Statement of Common Ground with East Riding of Yorkshire Council (draft)

Revision 2

September 2025

- 1.1.1 This Statement of Common Ground (hereafter referred to as the 'SoCG') has been prepared to support the Examination of the Development Consent Order (DCO) application (the 'DCO Application') for Peartree Hill Solar Farm (the 'Proposed Development').

Figure 7.1: Designated Sites and Ecological Mitigation and Enhancement Areas

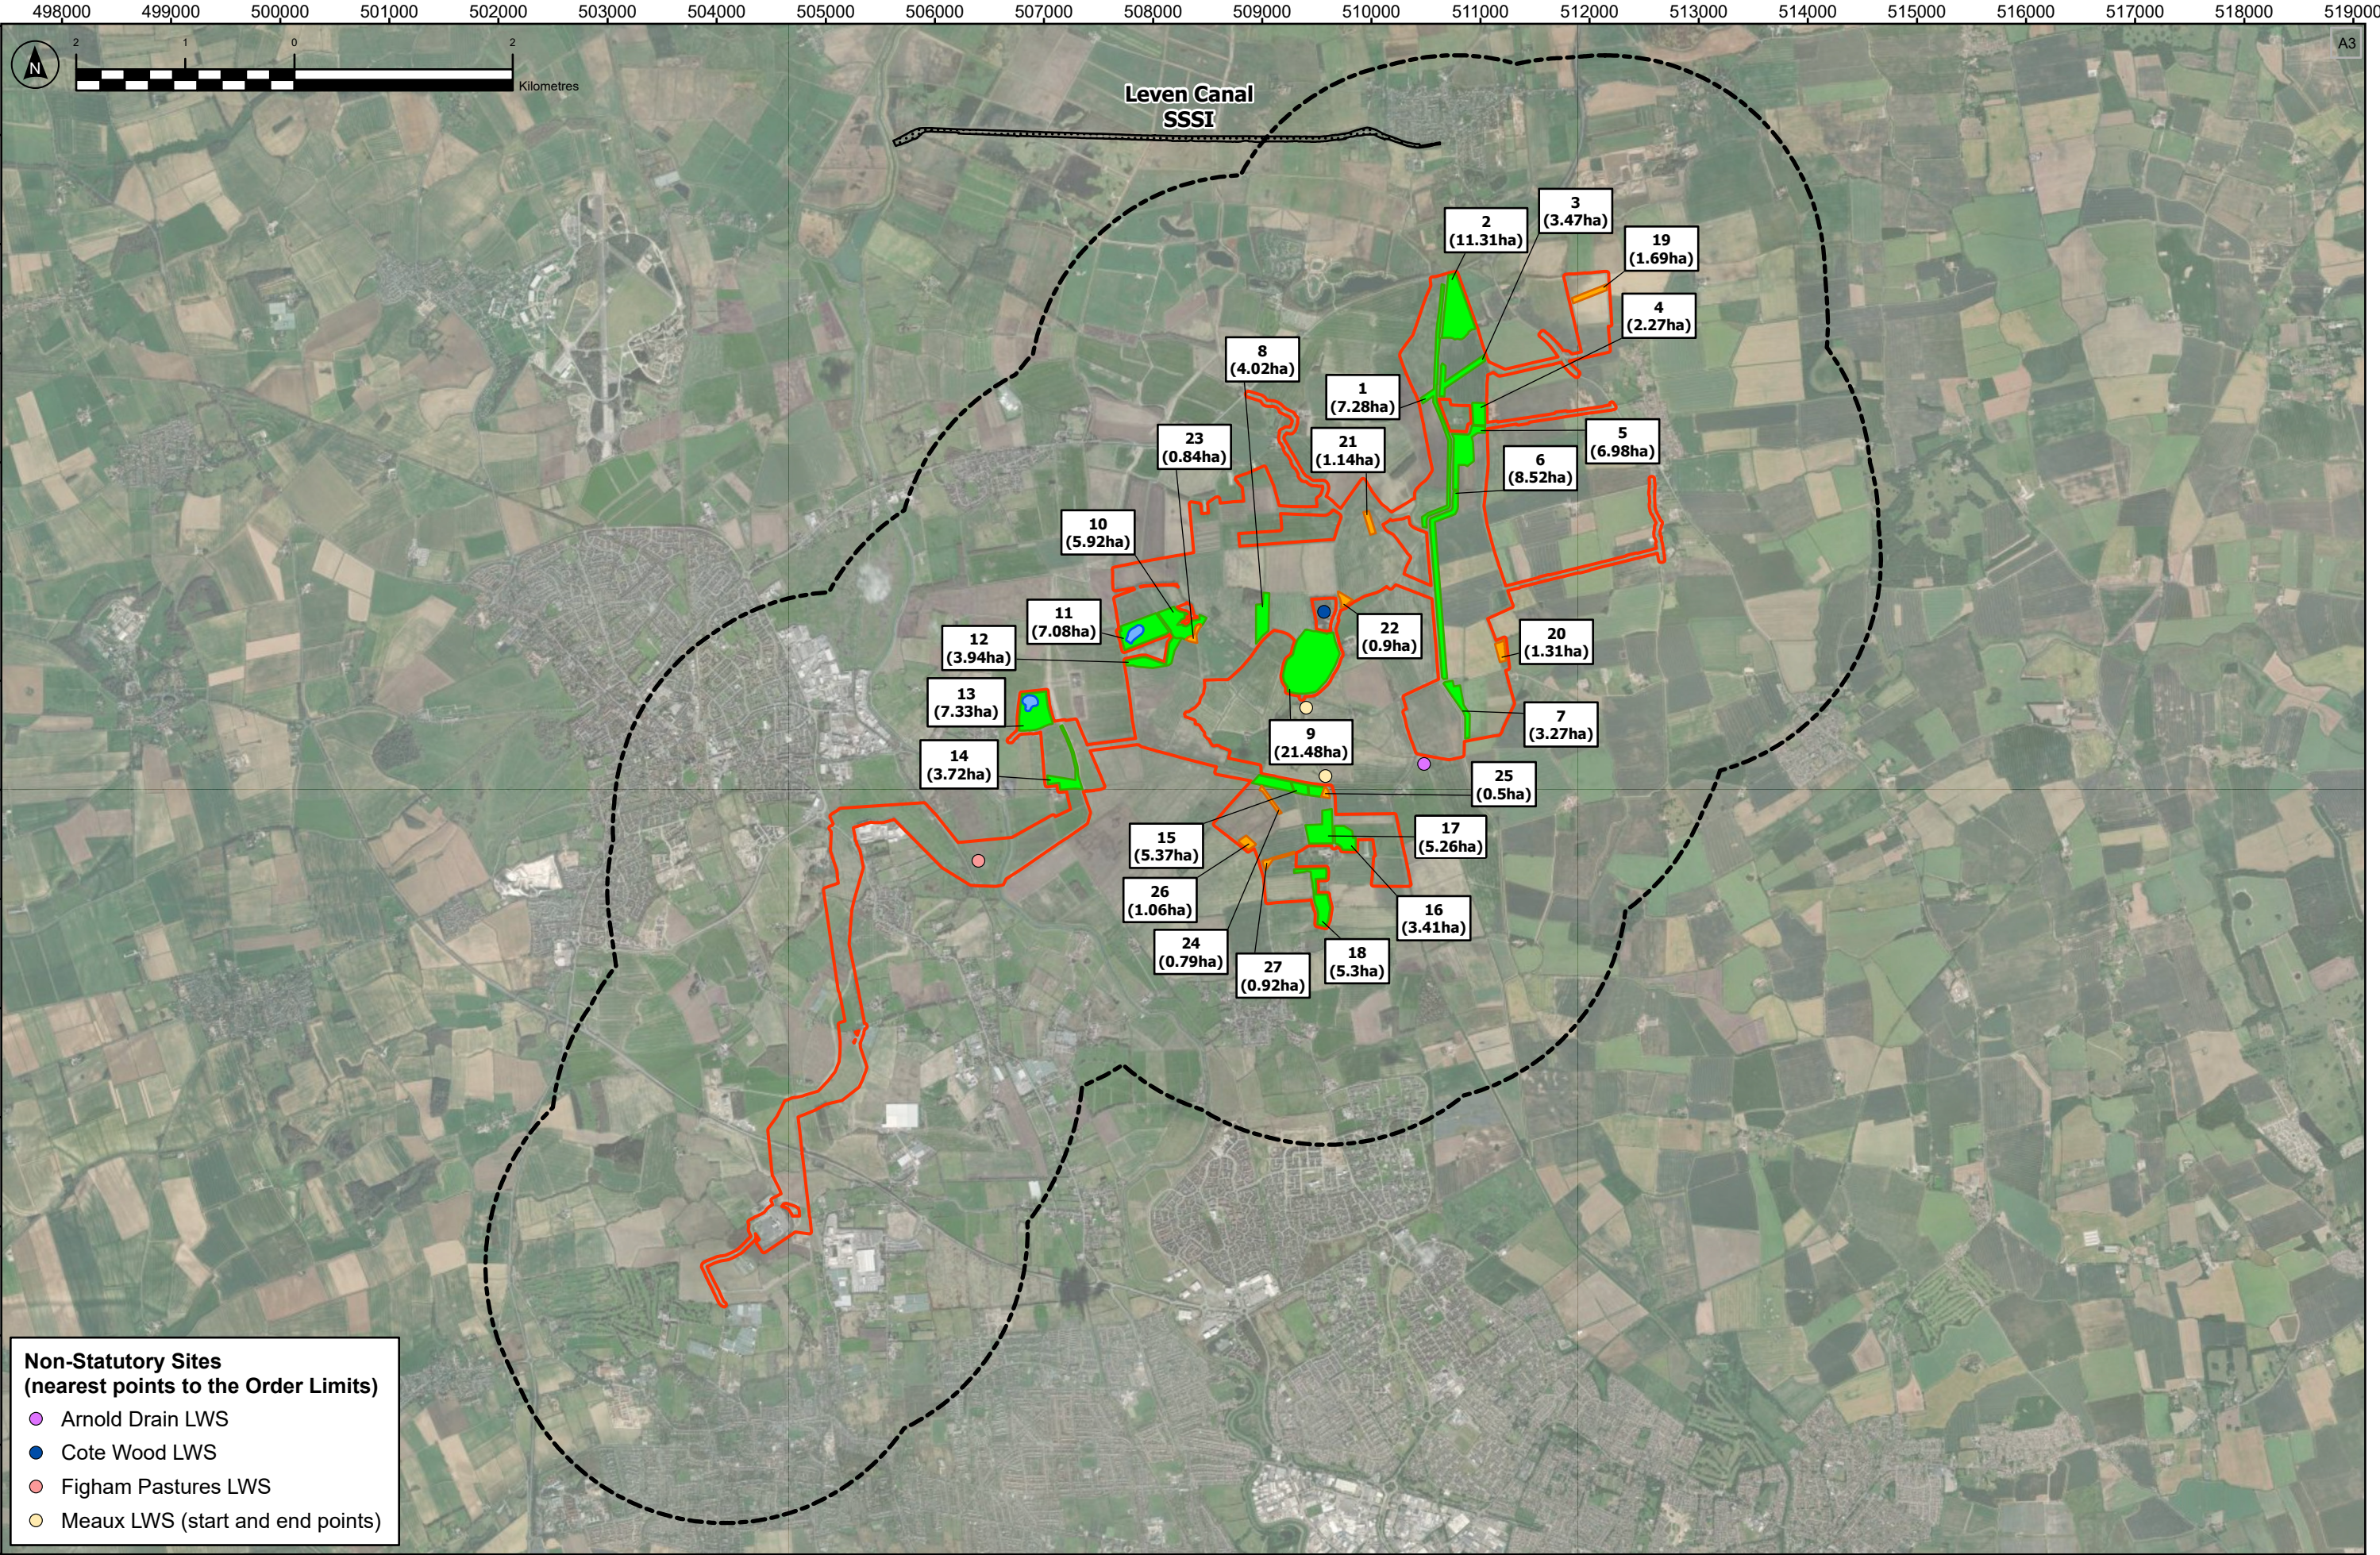
ERYC09	Protected sites – suitability of mitigation areas (enclosure and disturbance from	East Riding of Yorkshire Council has concerns in relation to the extent of enclosure of mitigation area 11 (Field E6) and the introduction of permissive paths around mitigation areas 11 (Field E6) and 9 (Field D18), stating that the land needs to be reasonably open and human activity minimised.	The Outline LEMP [EN010157/APP/7.5 Revision 3] has been updated to provide further assessment of the suitability and the potential carrying capacity of each mitigation area to deliver mitigation for the intended species. The updated document is submitted at Deadline 1.	Under discussion

Ref	Topic	East Riding of Yorkshire Council's Position	Applicant's Position	Status
	recreational activities) <i>Biodiversity</i>	East Riding of Yorkshire Council notes that mitigation area 13 (Fields E13 and E14) is well-placed, has good likelihood for proposed scrapes to hold water, and that existing hedgerows do not pose a constraint to use.	The Applicant is investigating ways to address issues of disturbance due to permissive paths around mitigation areas, such as the re-routing of the proposed permissive paths around mitigation areas 9 and 11, the use of signage in appropriate locations instructing dog walkers to keep their dogs on a lead and/or additional fencing. The Applicant will continue to engage with East Riding of Yorkshire Council on this topic. The Outline LEMP [EN010157/APP/7.5 Revision 3] and ES Volume 3, Figure 3.4: Indicative Environmental Masterplan [APP-058] will be updated to reflect any changes as necessary and submitted at subsequent deadlines. The Applicant will continue to engage with East Riding of Yorkshire Council on this topic.
